Proposed Residential Development, Deveron Road, Huntly

Combined Stage 1 & Stage 2 Road Safety Audit

Report No. A113162 – RSA2

**RESPONSE TO STAGE 1/2 ROAD SAFETY AUDIT
 22/04/19**

REFUSE VEHICLE SWEEP PATH (1:250)

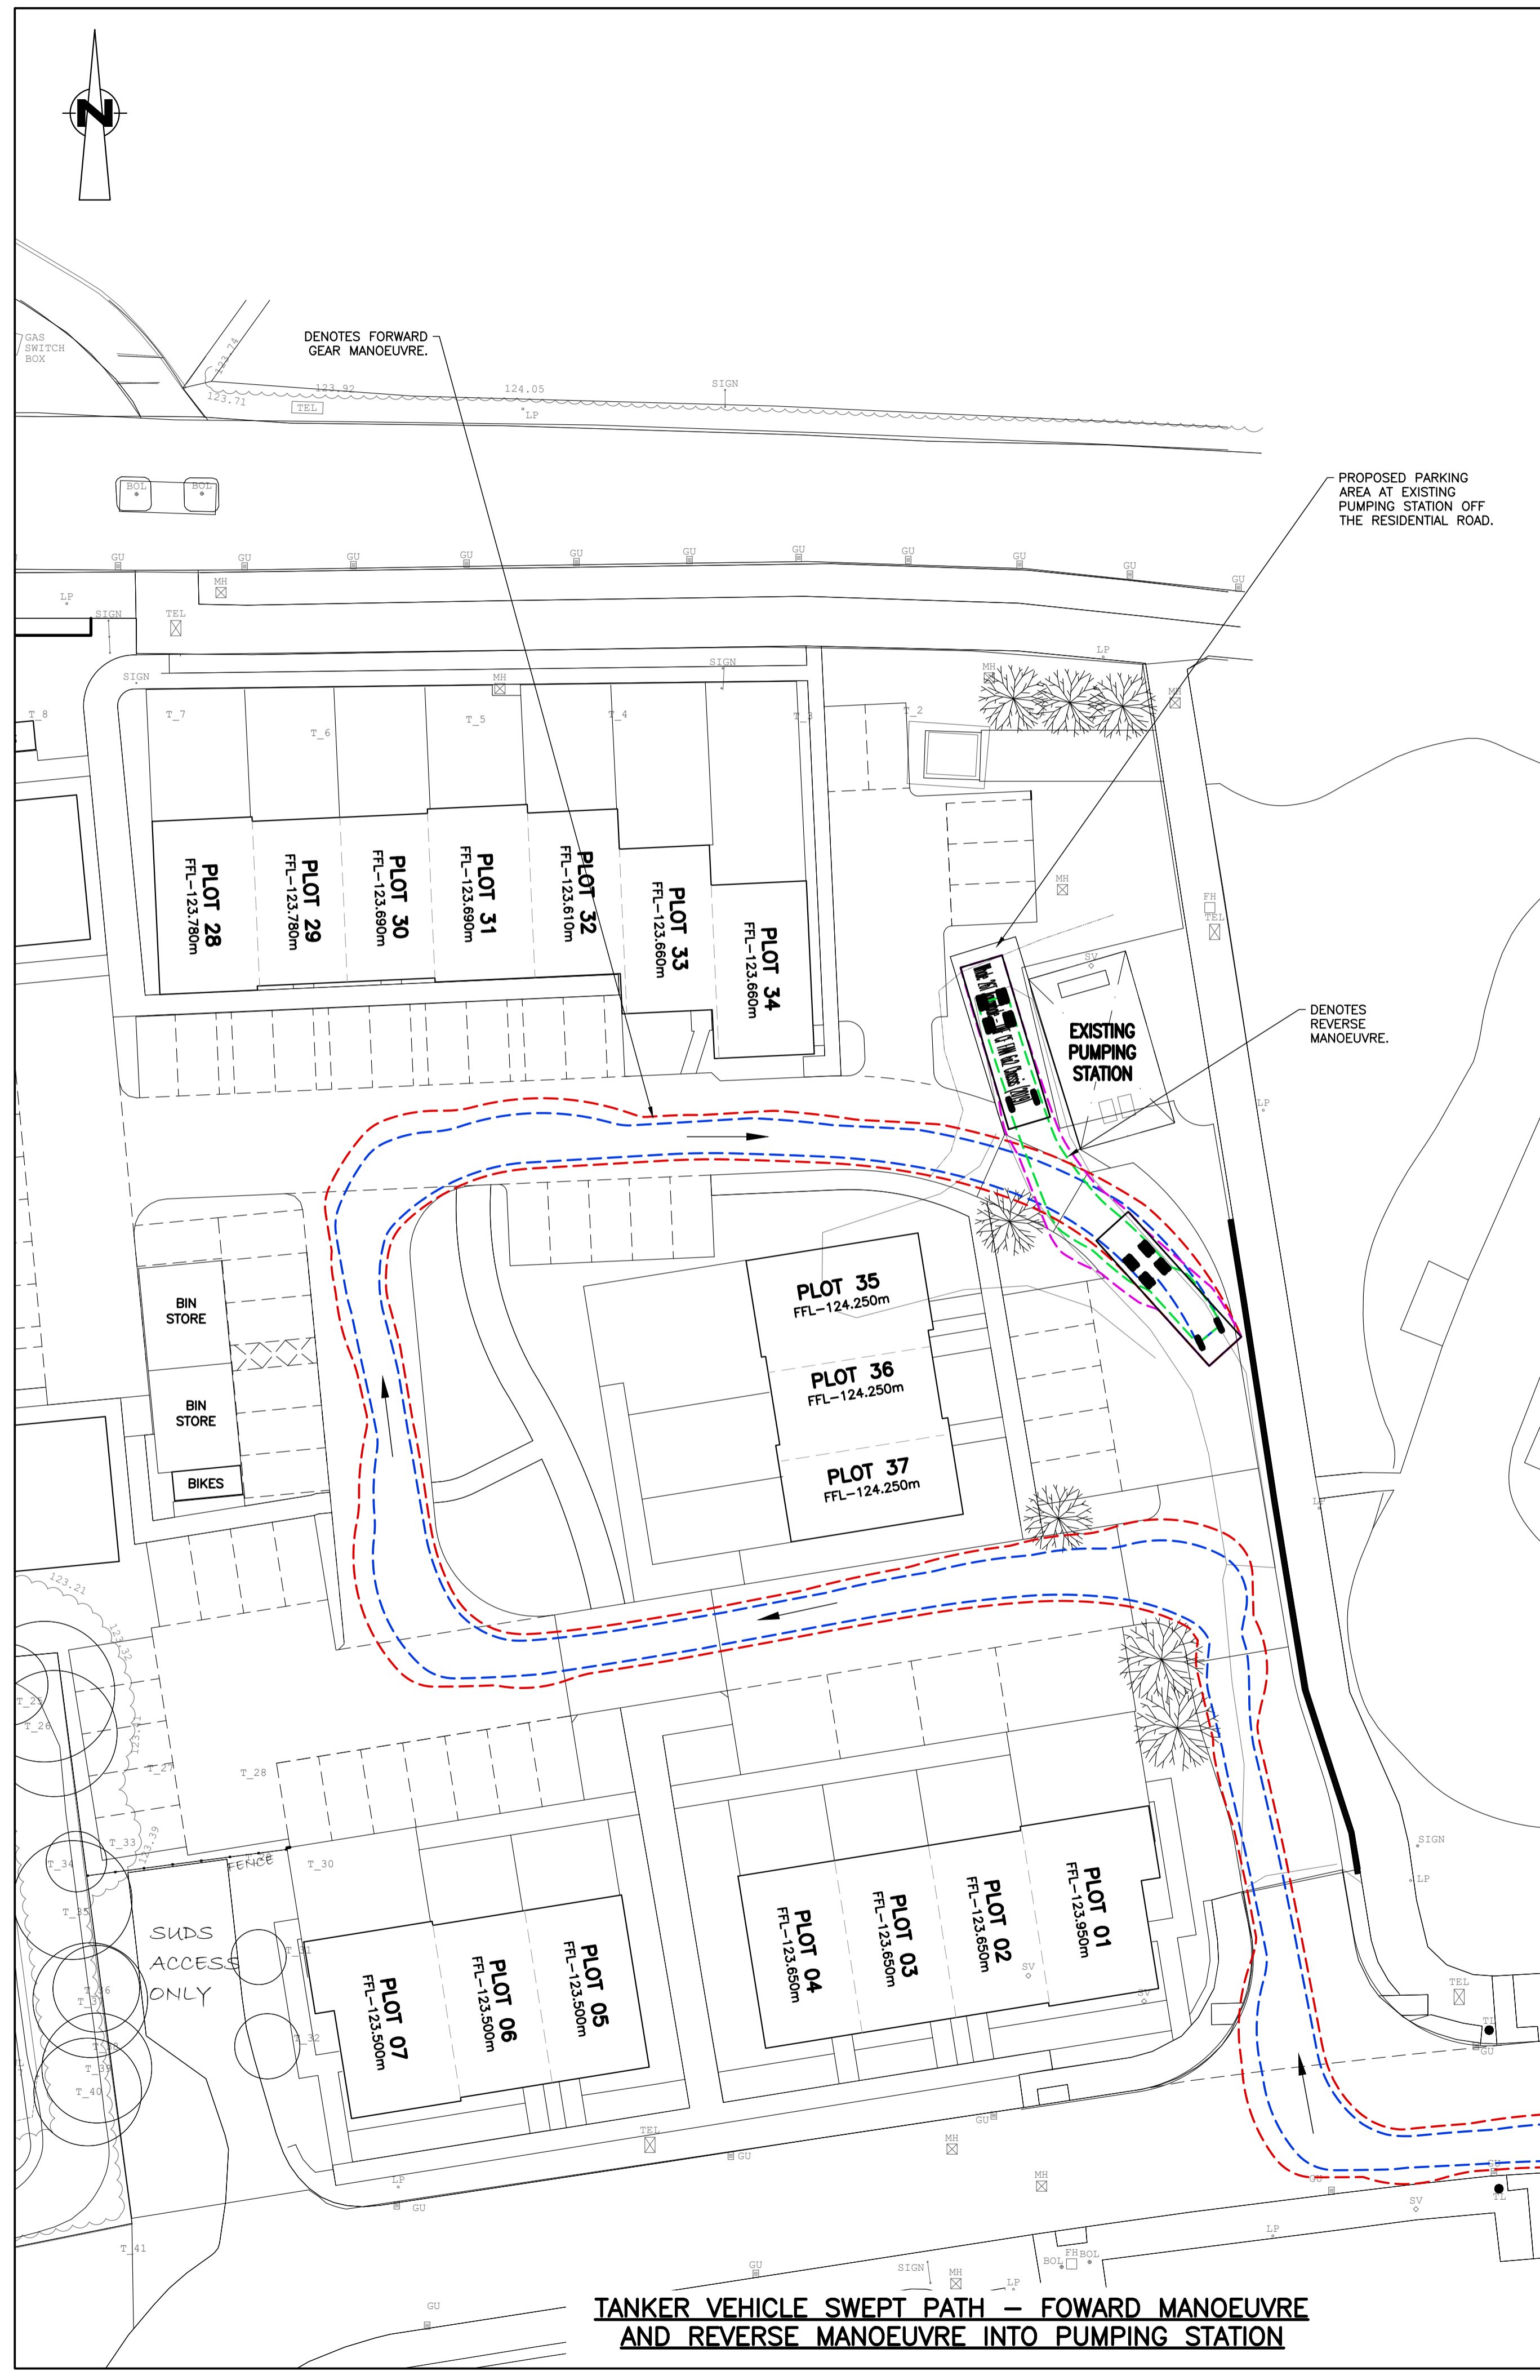
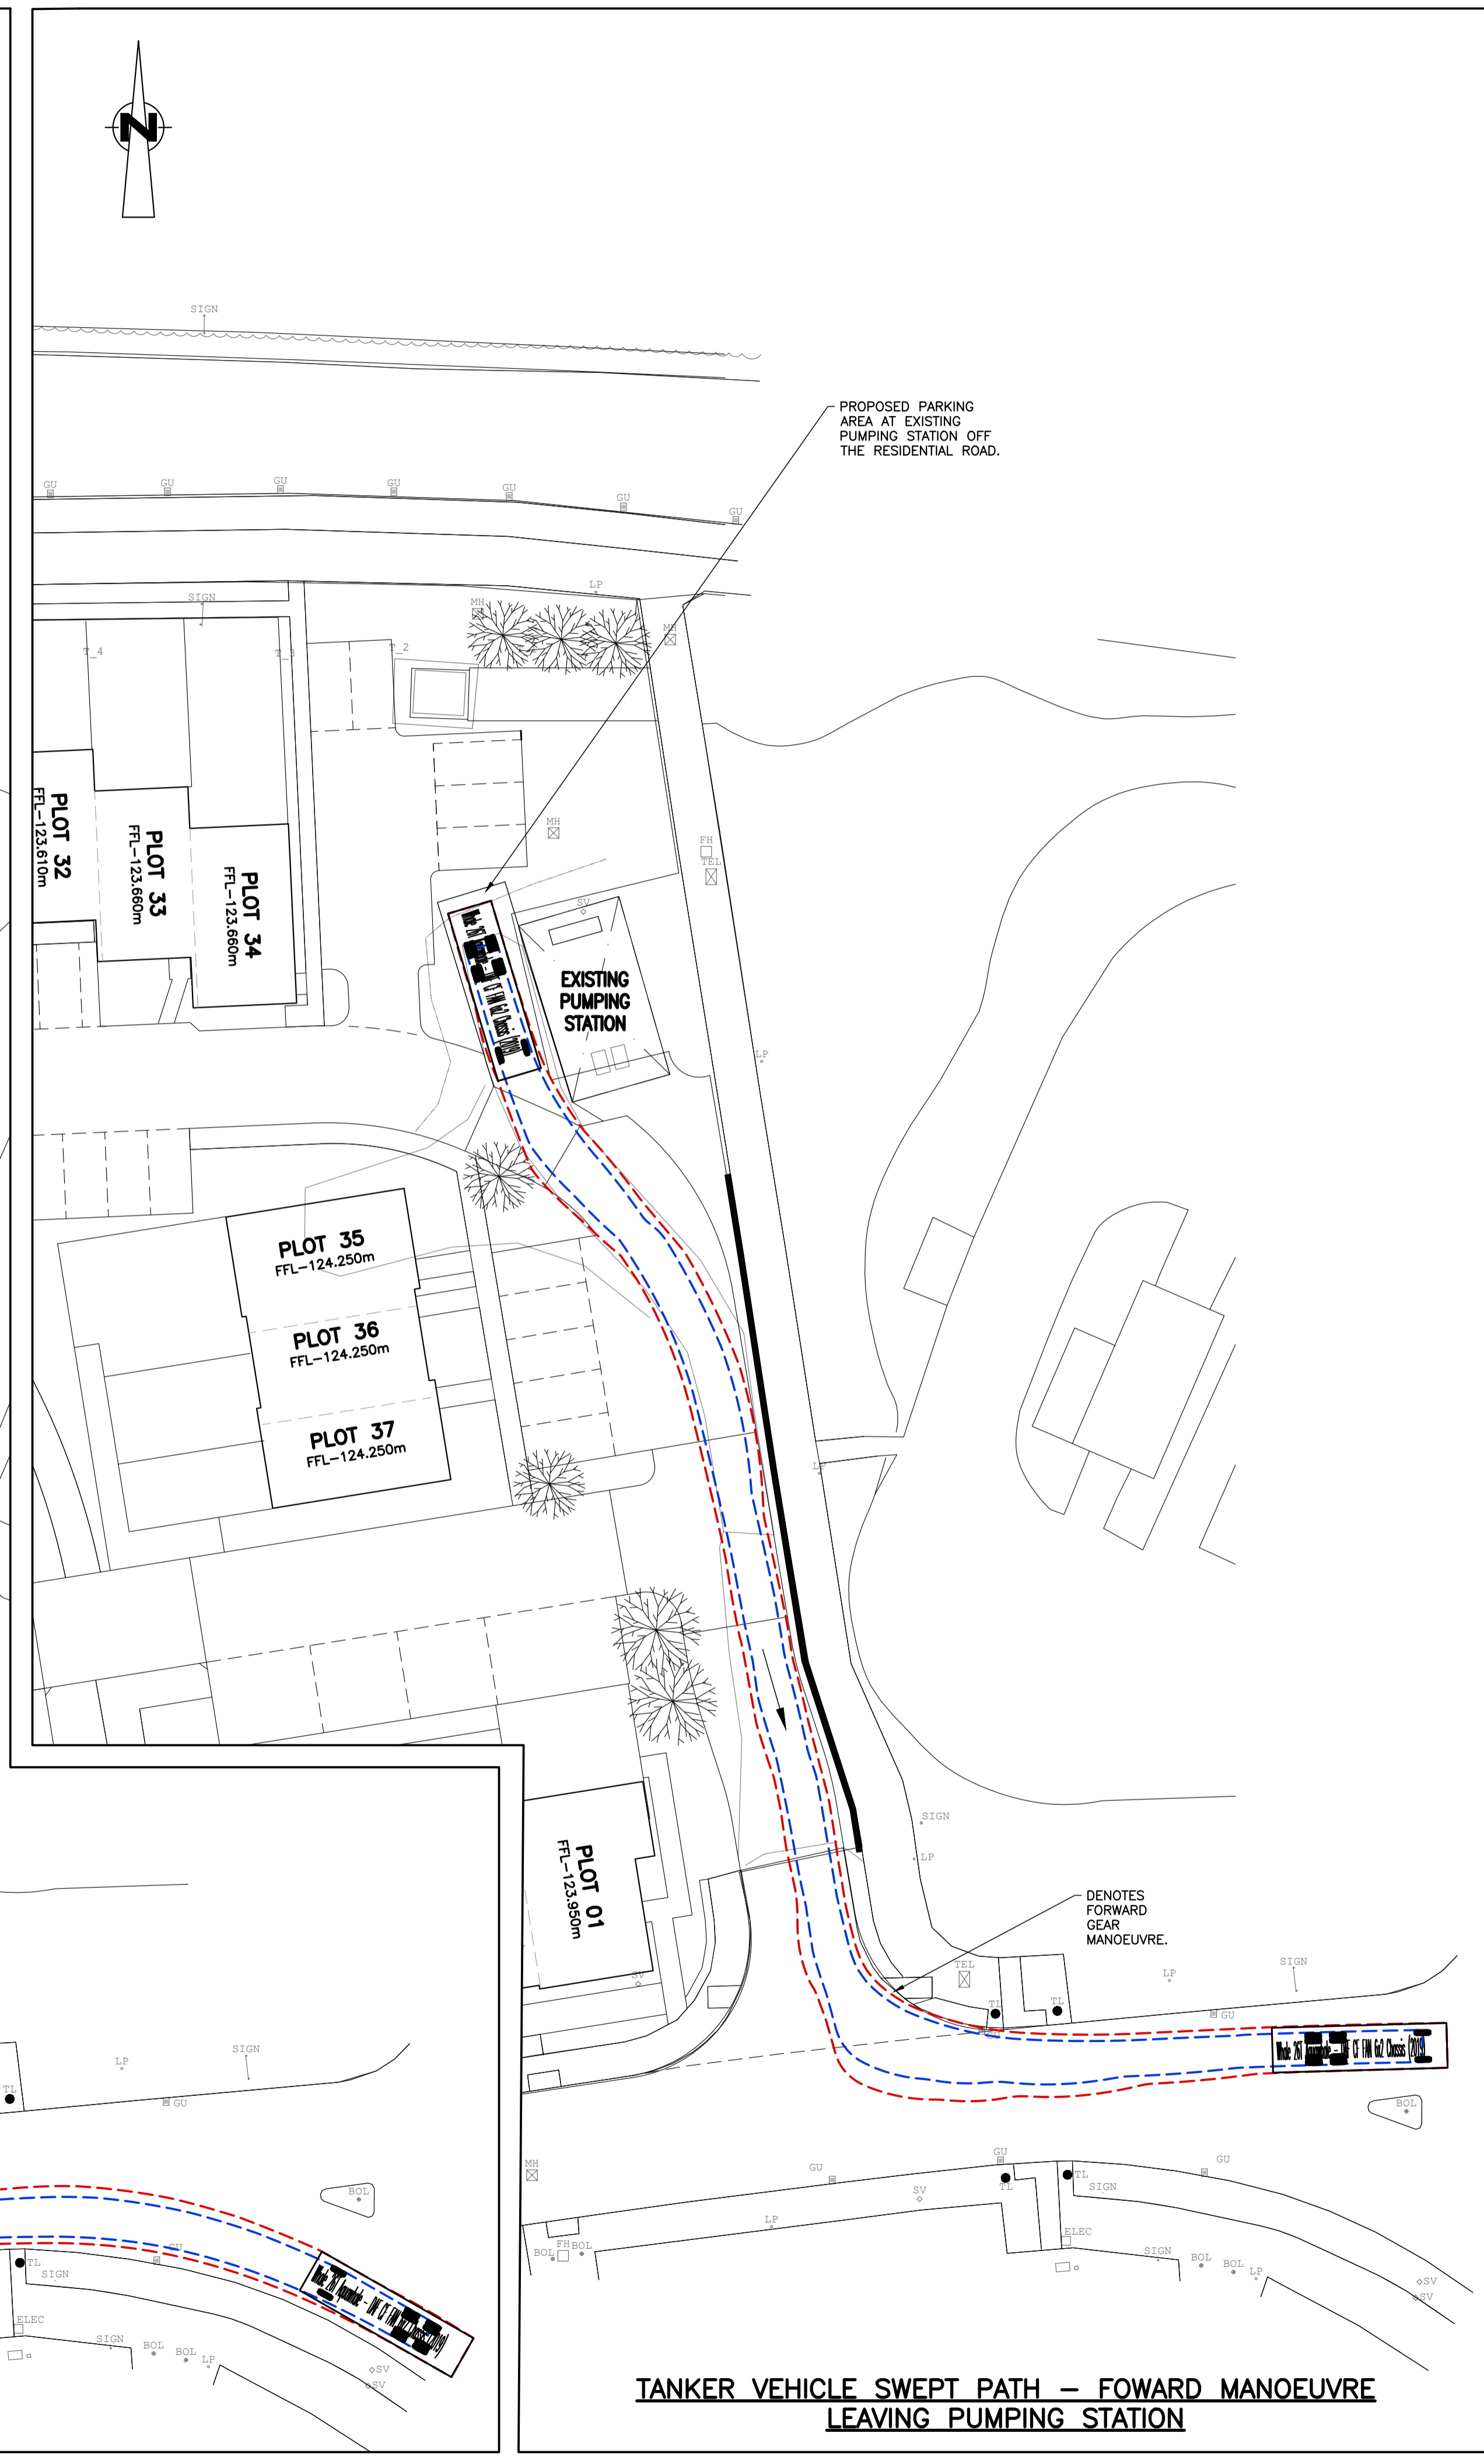
The swept path drawing for the refuse vehicle also shows the full width of the road is required to access the site leaving no safe space for pedestrians. The lack of pedestrian facilities within the site is likely to increase risk of vehicle collisions with pedestrians and instances of slip, trip and fall type accidents with pedestrians walking on uneven ground.
